Recommendation Report for Planning Permission for Works or Extension to a Dwelling

REF NO: LU/166/21/HH

LOCATION: 3a Butts Mead
Littlehampton
BN17 6GP

PROPOSAL: Single storey rear extension & first floor extension over existing.

C			
B			
A			
Client	Mr & Mrs Langmaid		
Address	3a Butts Mead : Wick		
Drawing	Plans	No.	282:1
Scale	1:50	Drawn	B
		Date	may '21

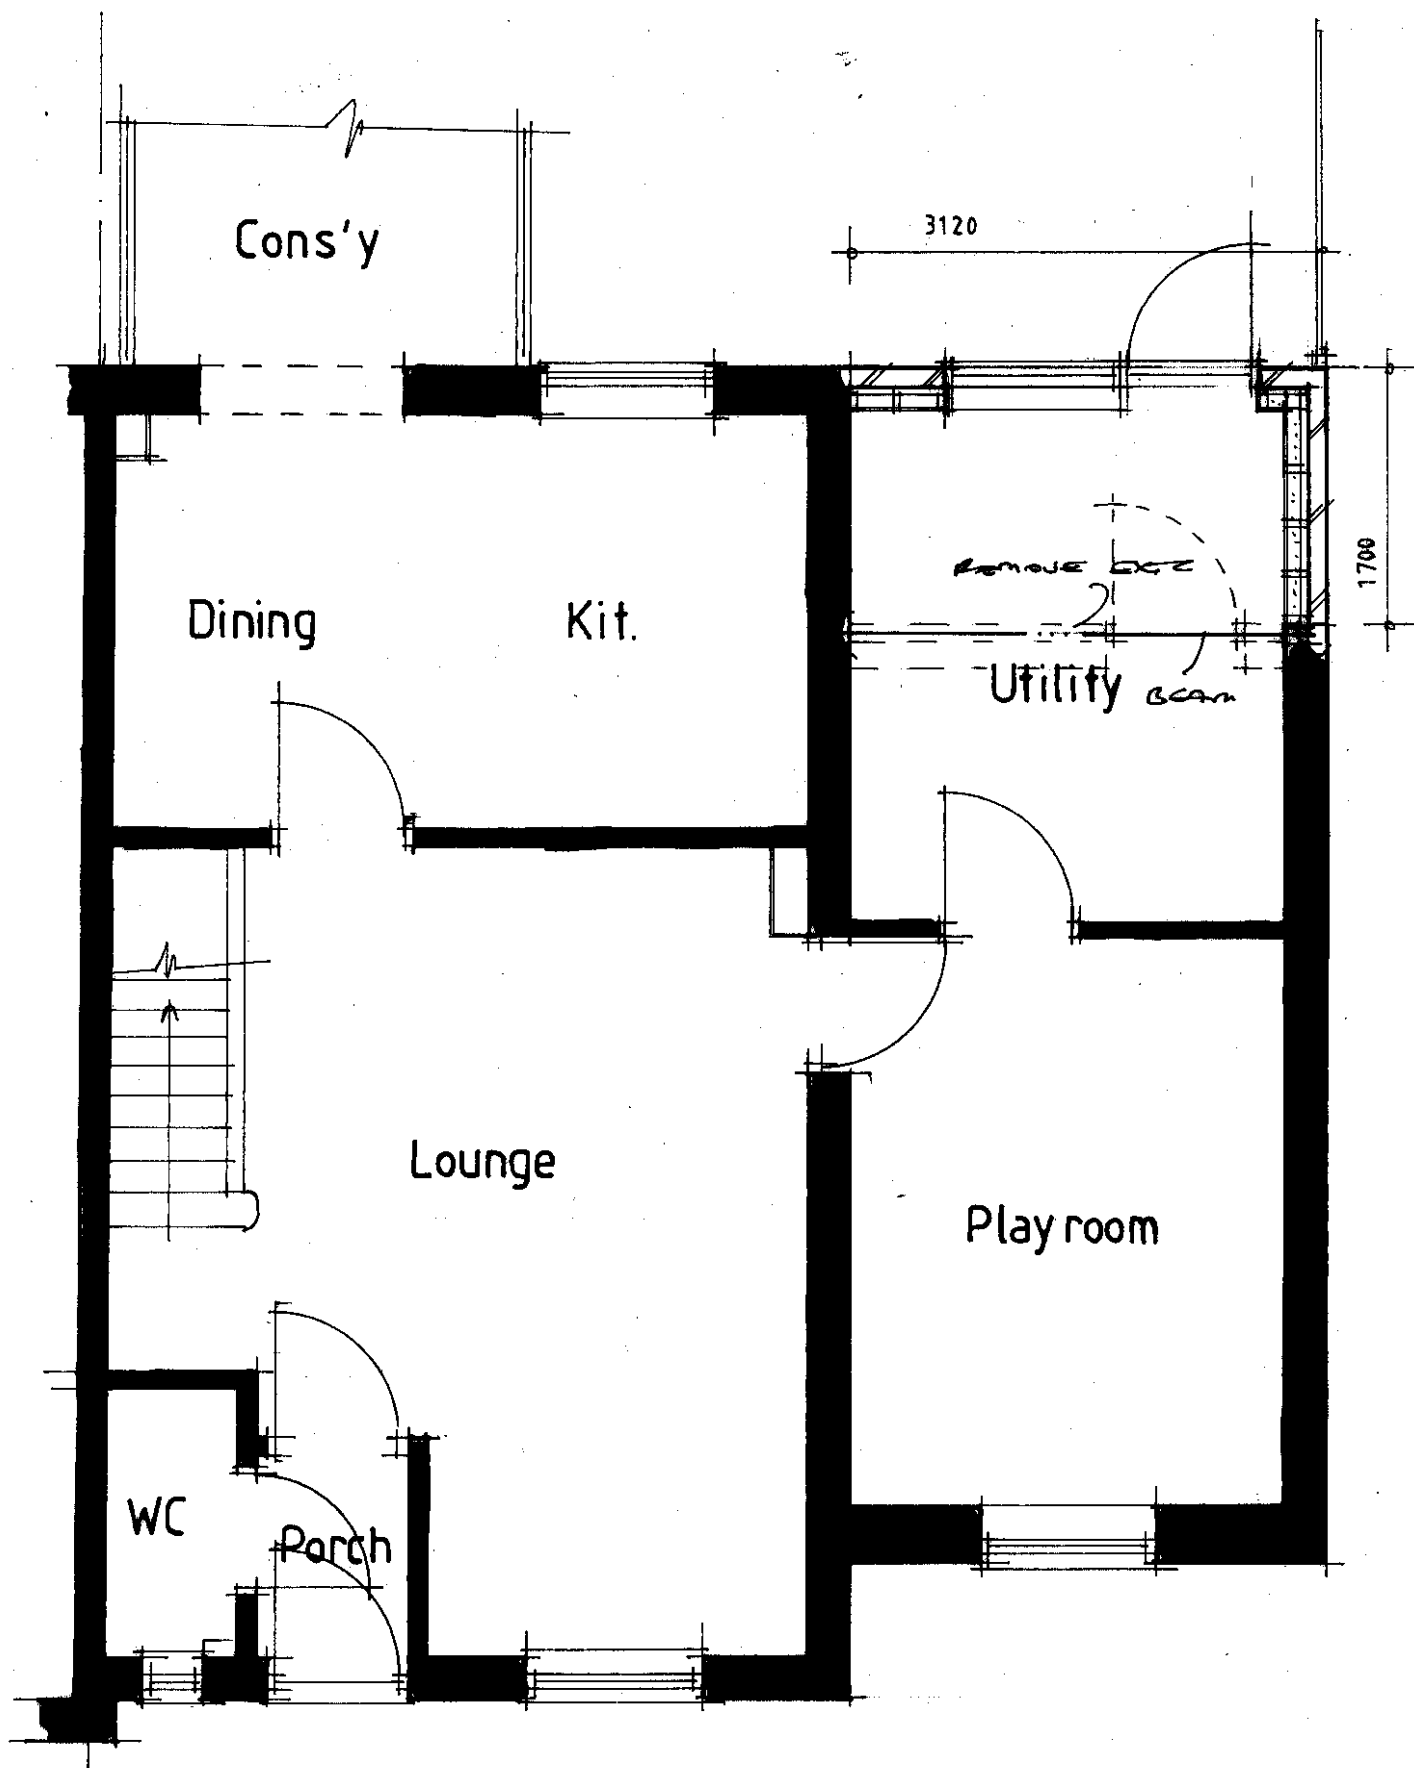
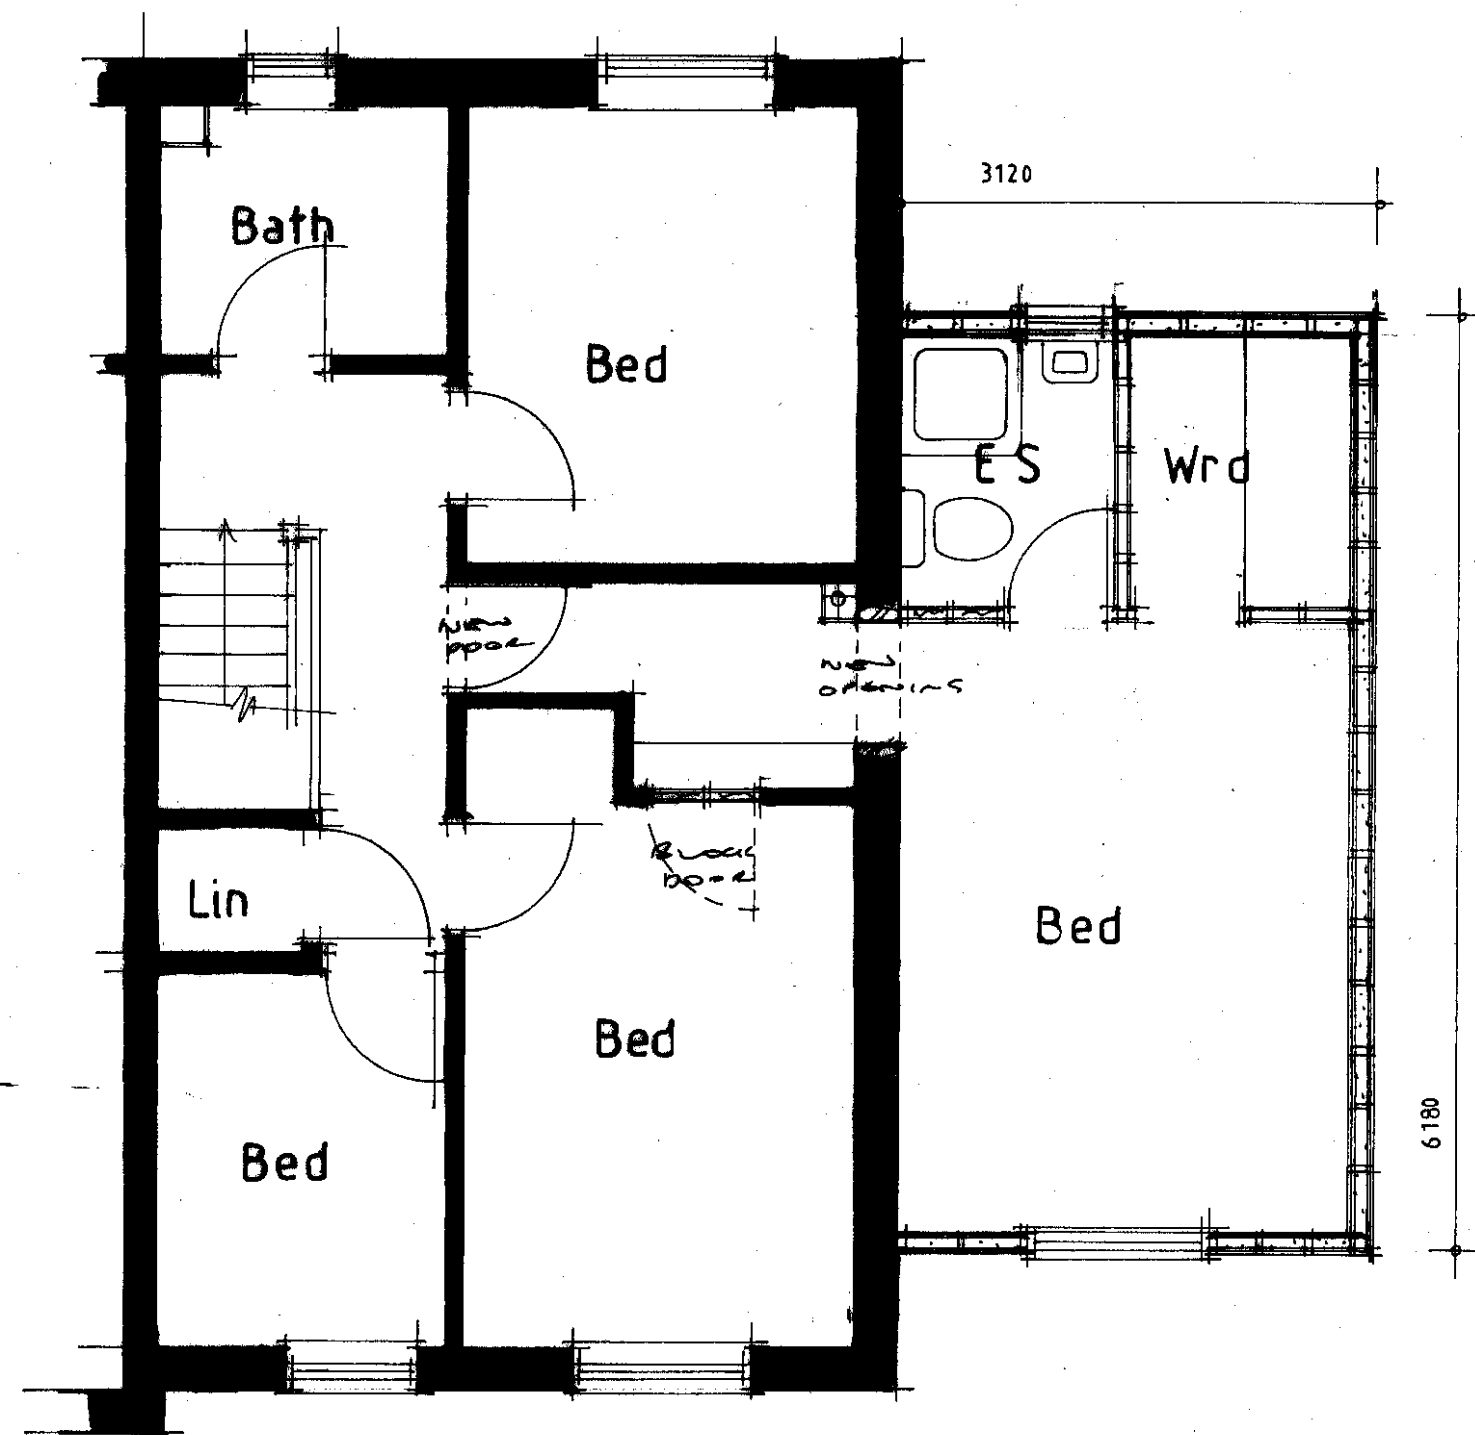
The proposal seeks to extended at first floor level above an existing single storey pitched roof protrusion and extend at ground floor level to the rear of this. The size of the extension is appropriate for its intended use and a suitable scale when compared with the host dwelling.

The bulk of the extension is adjacent to the neighbouring properties flank wall and therefore this will not impact views out of neighbouring properties or overshadow private amenity space. The rear extension is single storey only and be built with a flat roof to minimise any negative impacts on the neighbours.

C			
B			
A			
Client	Mr & Mrs Langmaid		
Address	3a Butts Mead: Wick		
Drawing	Section + Elevations	No.	2821:2
Scale	1:50 1:100	Drawn	8
		Date	MAY '21

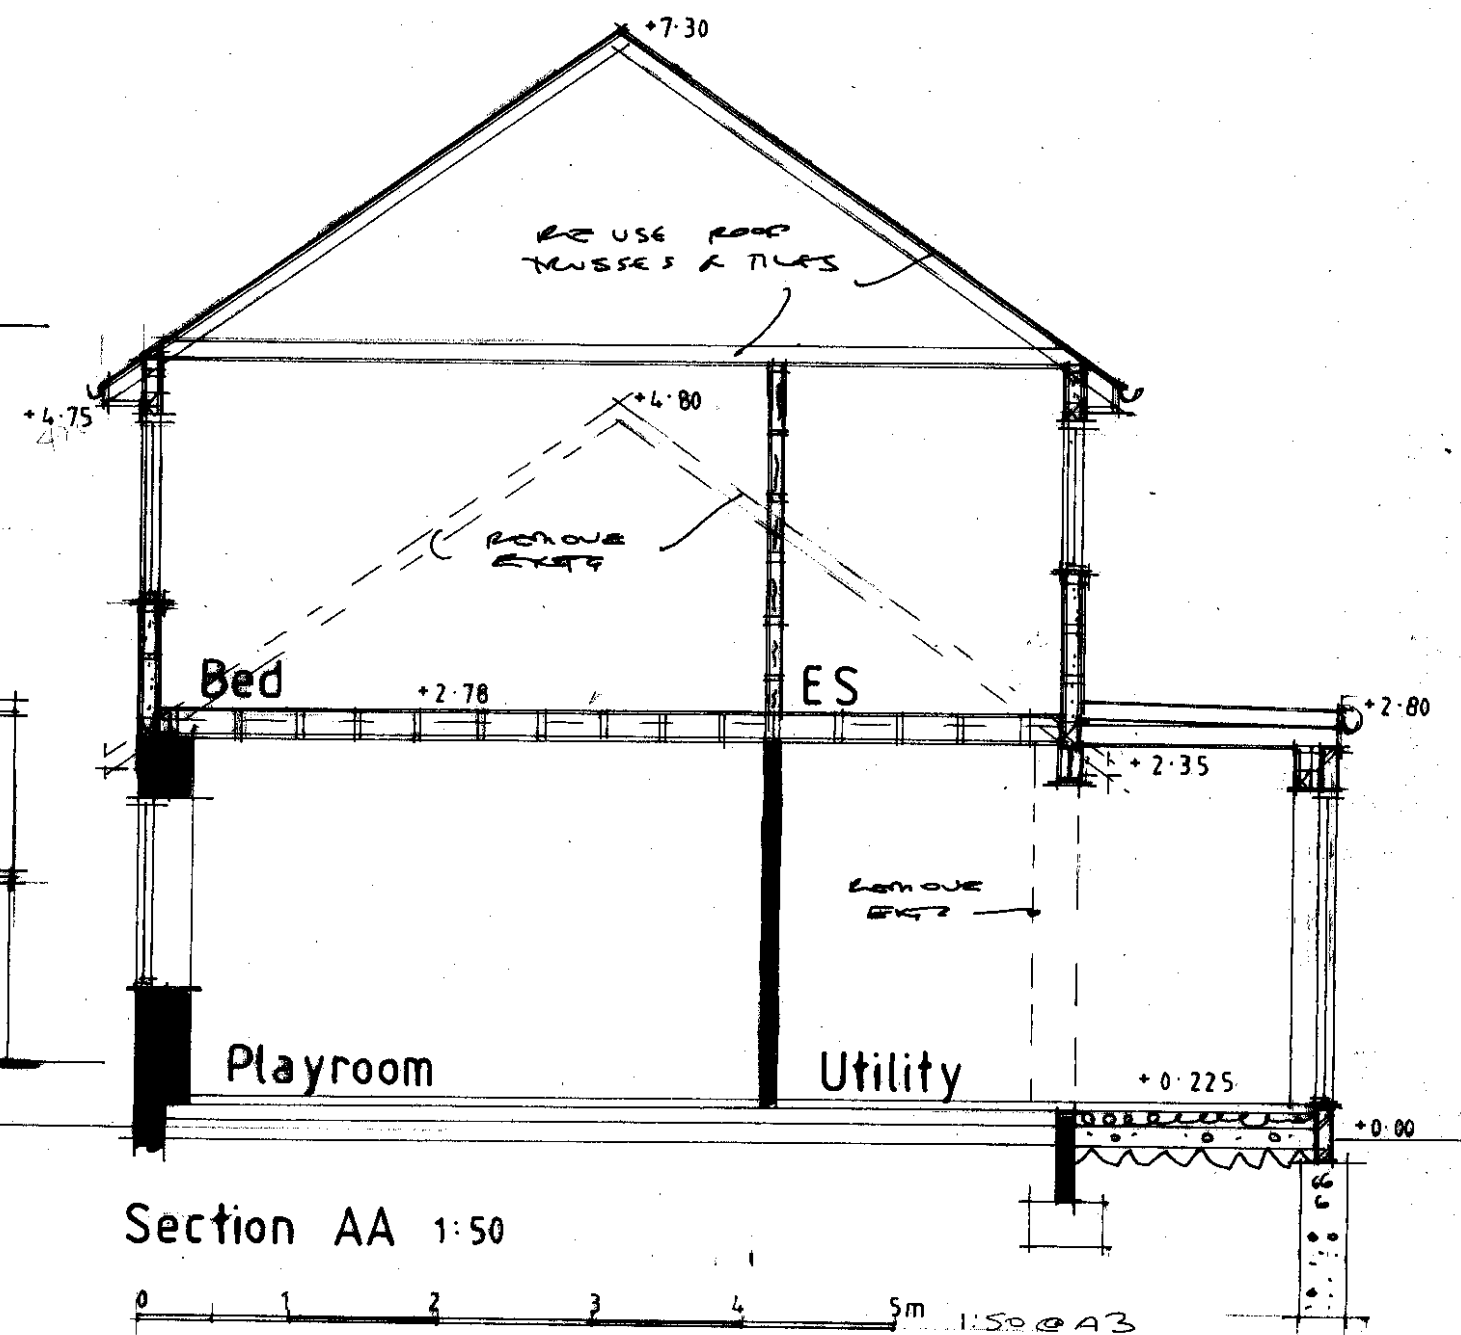
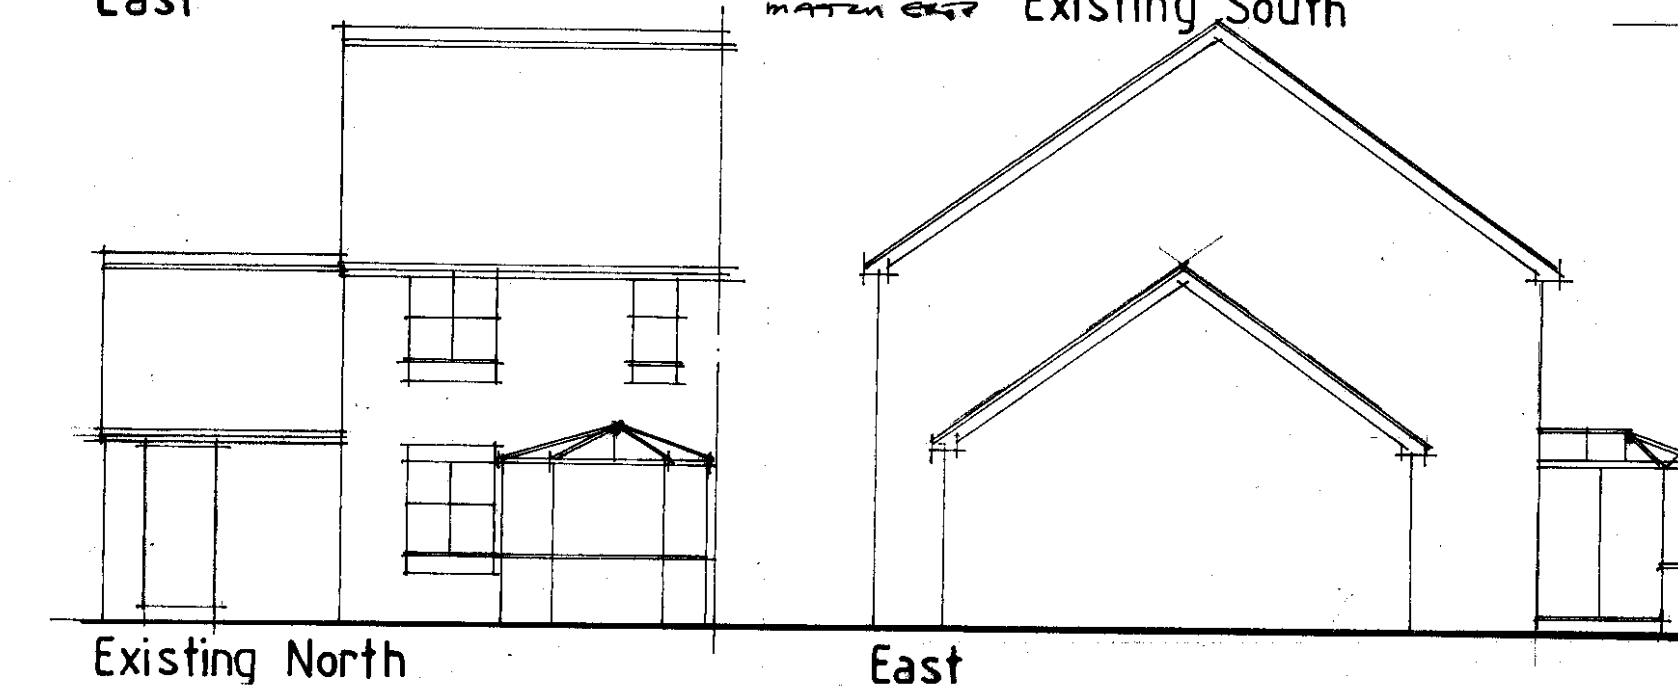
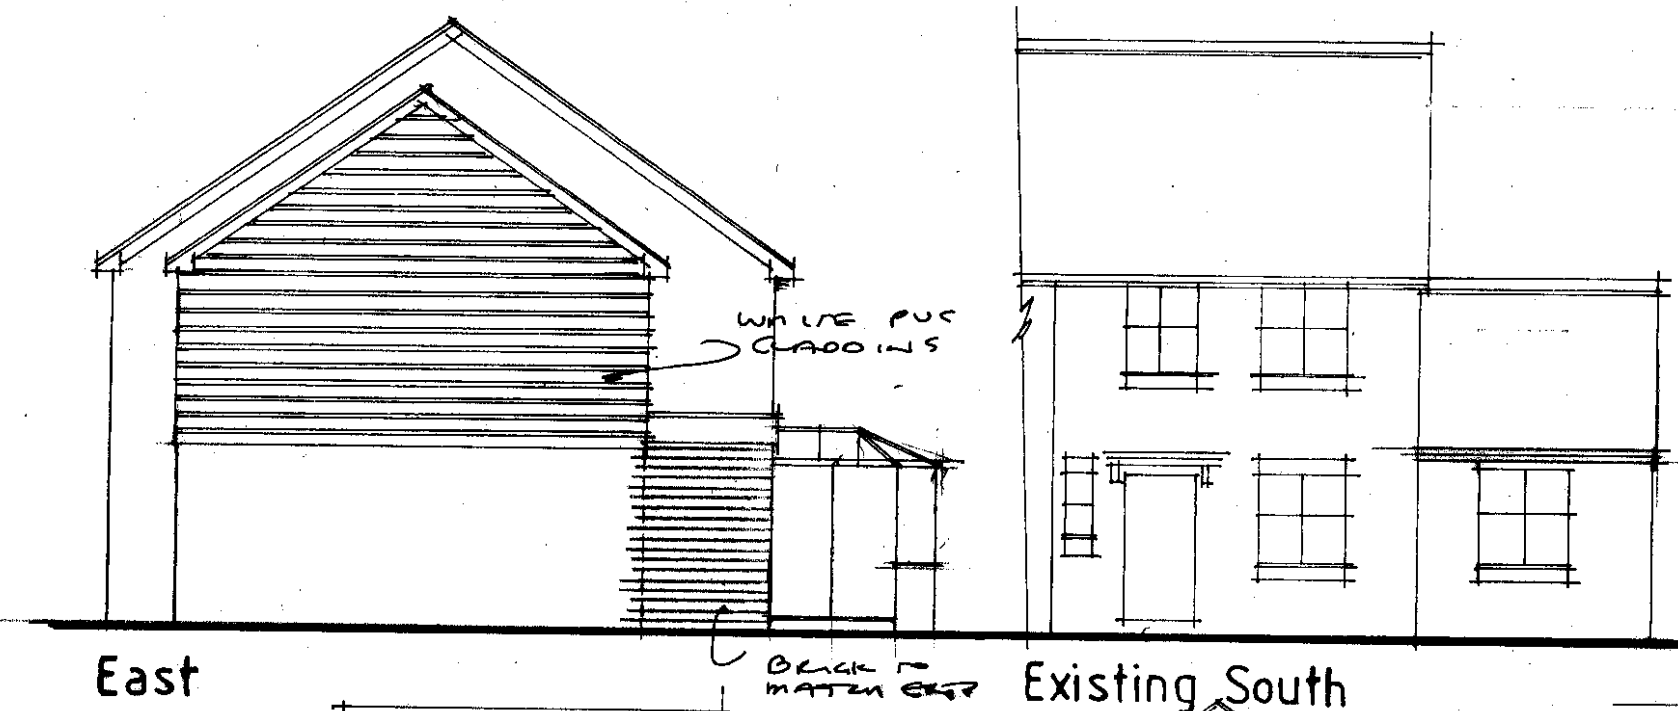
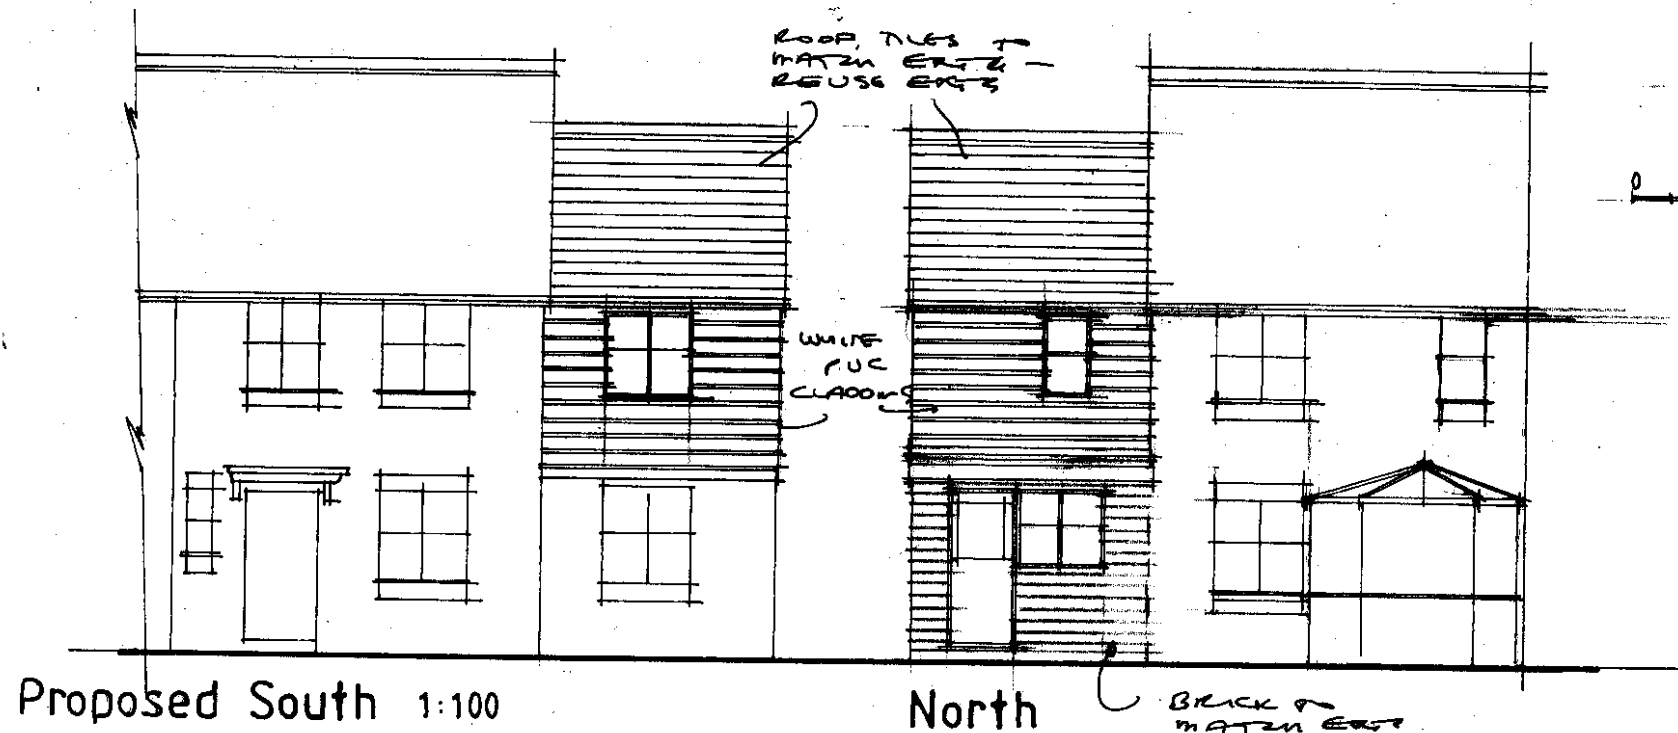
The extension will have the effect of closing the gap at first floor level between dwellings which will negatively impact the established special characteristics of the street. Arun Design Guidance states that to be acceptable first floor extension should be set back from the front of the dwelling by a minimum of 2m, be set back from the boundary by 1m and be 2m from neighbouring properties to ensure that a terracing effect is not produced. The extension will be set on the boundary and be less than 2 m away from the neighbouring property, it is set back from the host dwellings frontage however only by half of the recommend distance. This is repeated by D DM4 (d) of the Arun Local Plan which states extensions to first floors should be a minimum of 1m away from the boundary. It is therefore considered to conflict with design guidance and policy D DM4 as it is expected to produce the effect of terracing the buildings.

The eaves and ridge height of the extension considerably lower than those of the two-storey dwelling. The pitch matches that of the existing dwelling.

It is proposed that the extension be built from material which are not currently found on site, it is felt that

the choice of Pvc cladding does not sympathetically relate well to the host dwelling being traditionally built from brick.

The extension will be visible from the roadside as it is to be located directly above the previously converted garage. The street scene consists of uniformly design properties and through the choice of materials it is considered to be visually dominate on the host dwelling andnot sympathetically relate well to its surroundings.
